20 November 2012

RE: MATERIALS RECYCLING FACILITY, ST PETERS – MP11_0086

Graham Jahn AM
Director
City Planning | Development | Transport

Figure 4-14: Extract from Sheet 3 of Drawing No.9167-12 at Appendix 8.

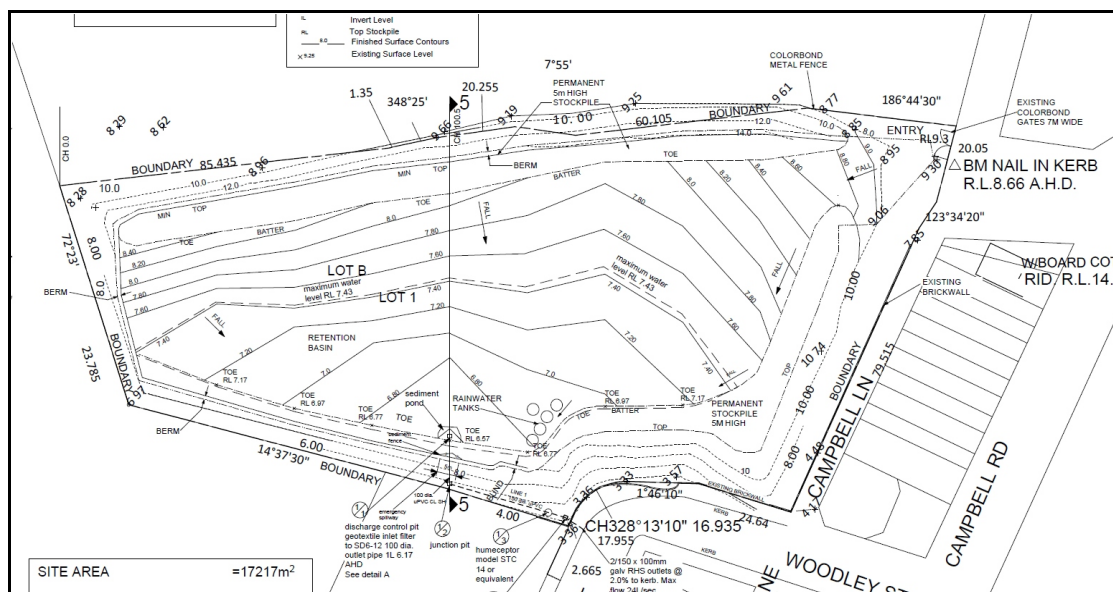
A review of the documentation by the City's Development Engineer has concluded that insufficient information was submitted with the application to demonstrate where the emergency spillway would exit the site, as well as the design parameters adopted to safely convey this overflow using the existing road carriageway system and taking into account the velocity depth ratio.

The Department should request further assessment and quantification on the emergency overflow from the site to confirm that there are no flooding implications downstream due to inadequate pipe capacity, blockage in the existing system or trappings in existing low point/s in Holland Street. Where considered necessary by the Department, consultation should occur with the Council's City Infrastructure Unit regarding the design and documentation of the recent Holland Street drainage upgrade works.

Proposed outlets to kerb and gutter in Holland Street as documented is not approved

- (c) There is insufficient information in the documents to demonstrate to Council where the emergency spillway would exit the site and the design parameters adopted to safely convey this spillway for all stages of the project using the existing road carriageway system taking into account the requirements for velocity depth ratio.

- (a) Prior to commencing any work, details of the proposed stormwater disposal and drainage from the development in accordance with Council's standard requirements and details of the provision and maintenance of overland flow paths must be submitted to and approved by Council. All approved underground connection details for the disposal of stormwater and drainage are to be implemented in the development.

- (d) Further discussions are to be undertaken with City's Infrastructure unit, who has been involved in the design and documentation of Holland Street drainage upgrade works.
- (e) The stormwater discharge from the site to comply with ANZECC water quality guidelines
- (f) An "Application for Approval of Stormwater Drainage Connections" must be submitted to Council with the appropriate fee at the time of lodgement of the proposal for connection of stormwater to the Council's drainage system in Holland Street.
- (g) A Positive Covenant must be registered on the title for all drainage systems involving underground connections to ensure maintenance of the approved connection

Figure 6-5: Plan showing the operational stage of the proposed development.

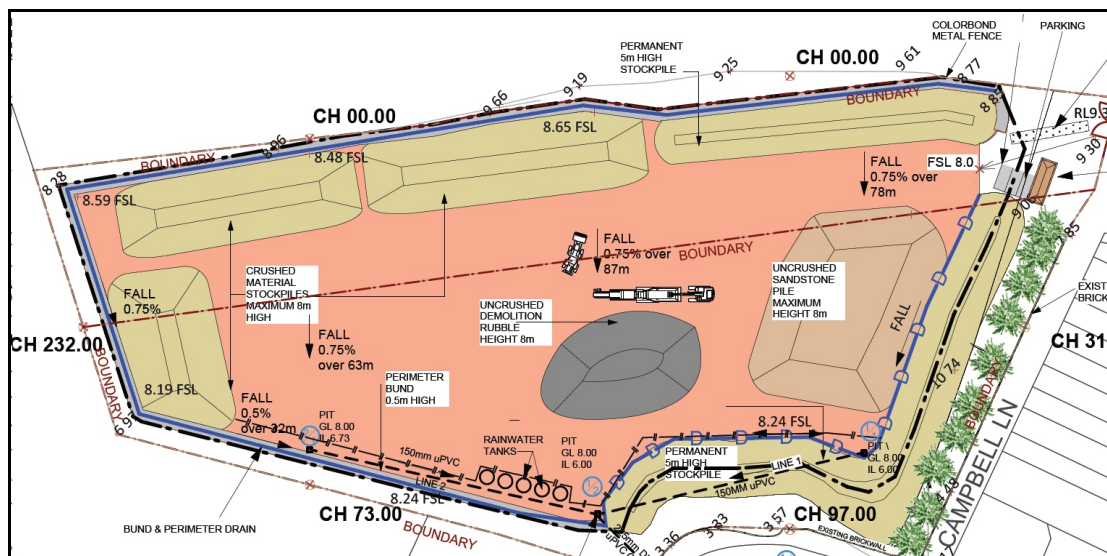
The site has been inspected by the City's Tree Management Officer, who has advised that there are 15 existing large Gum trees (*Eucalyptus* spp.) located along the northern boundary of the site. At present, a fence extends along the northern boundary, and this effectively excludes these trees from the main sandstone stock pile.

Any consent issued should require the retention of the 15 mature trees to provide screening and amenity to residential properties to the north of the site. Draft conditions have been included at Attachment A relating to tree protection.

- (a) The stand of 15 Eucalypt trees located along the northern boundary must be retained and protected for the entire construction phase;
- (b) The existing (colorbond) fence located along the North Boundary shall be retained in *situ*. This will ensure stand of approximately 15 Eucalypt trees (northern boundary) are protected during construction works;

- (c) Stockpiling, storage or mixing of materials, washing of equipment, vehicle parking, disposal of liquids, machinery repairs and refuelling, disposal of building materials such as cement slurry, siting of offices or sheds and the lighting of fires, must not occur within 4 metres of the trunk of the 15 Eucalypt trees located along the Northern Boundary;

- (d) Excavation must not occur within 4 metres of the trunks of the 15 Eucalypt trees located along the Northern Boundary. If excavation is proposed within this zone, the contractor must engage a qualified Arborist (minimum AQF level 5) to supervise the works. All works within this zone shall be undertaken in accordance with all directions given by the Site Arborist.
